**WEST SUSSEX COUNTY COUNCIL
INFRASTRUCTURE CONSULTATION**

SUBJECT: LU/26/10A

19-23 Surrey Street, Littlehampton

1 internally illuminated fascia sign and 1 externally illuminated hanging sign

title
Proposed Signage

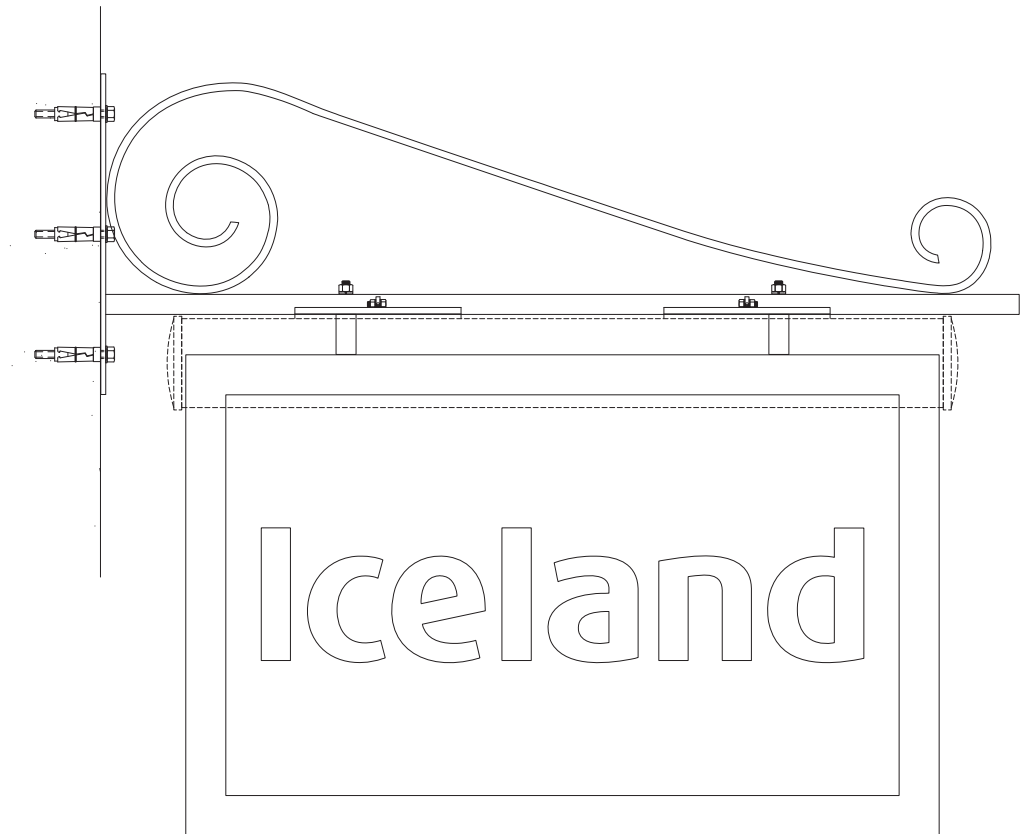
The proposal is for 1x fascia sign and 1x hanging sign for a retail unit. From an inspection of the plans alone, it does not appear that these signs are in a location where they could obstruct the highway. Furthermore the luminance levels for both signs are within standards.

Before the commencement of any operation, the applicant is advised to contact West Sussex County Council (Tel no: 01243 642105) to obtain a Section 177 Licence under the Highways Act 1980 to cover any structure that overhangs the highway.
